Application No: M/6/22/PL
Site Address: 88 Ancton Way Elmer Middleton-On-Sea PO22 6JP
Description of works: Demolition of existing bungalow and erection of 1 No 2-storey, 4-bedroom detached house with 3 No off road car parking spaces. This site is in CIL Zone 4 and is CIL Liable as new dwelling.

The Parish Council object to this planning application on the following issues

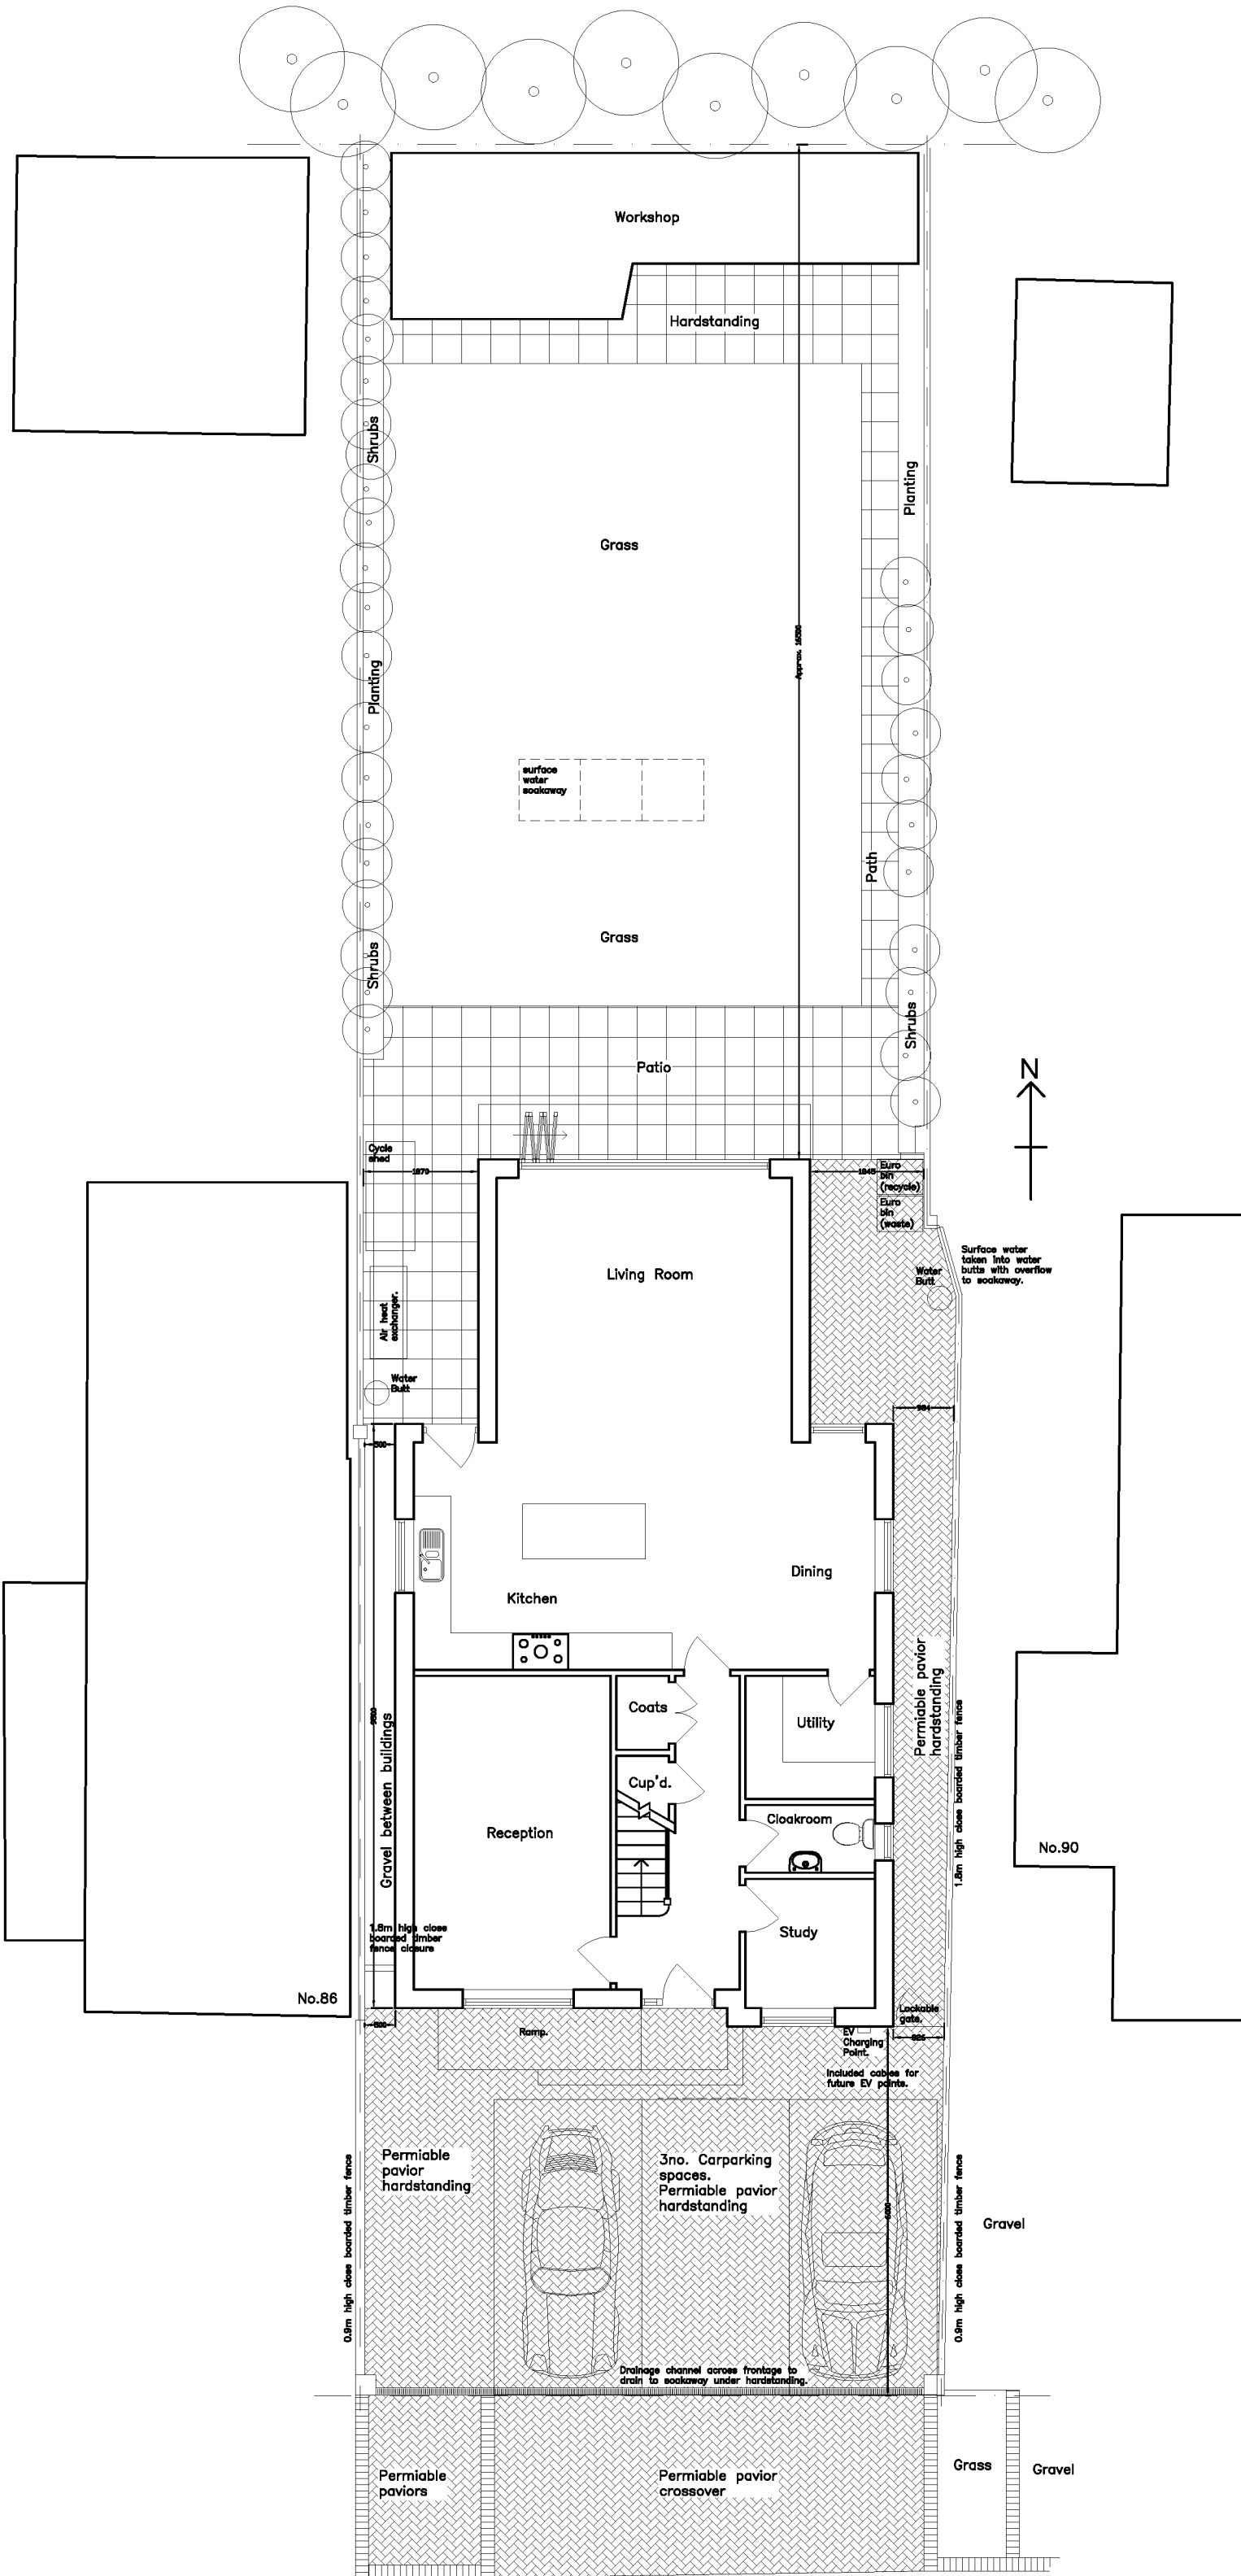
- Overall scale is out of keeping with surrounding properties
- Overdevelopment of the site
- Lack of suitable drainage plans in the application within an area that is known to flood
- Where is approval for widening the existing vehicular access across the site frontage
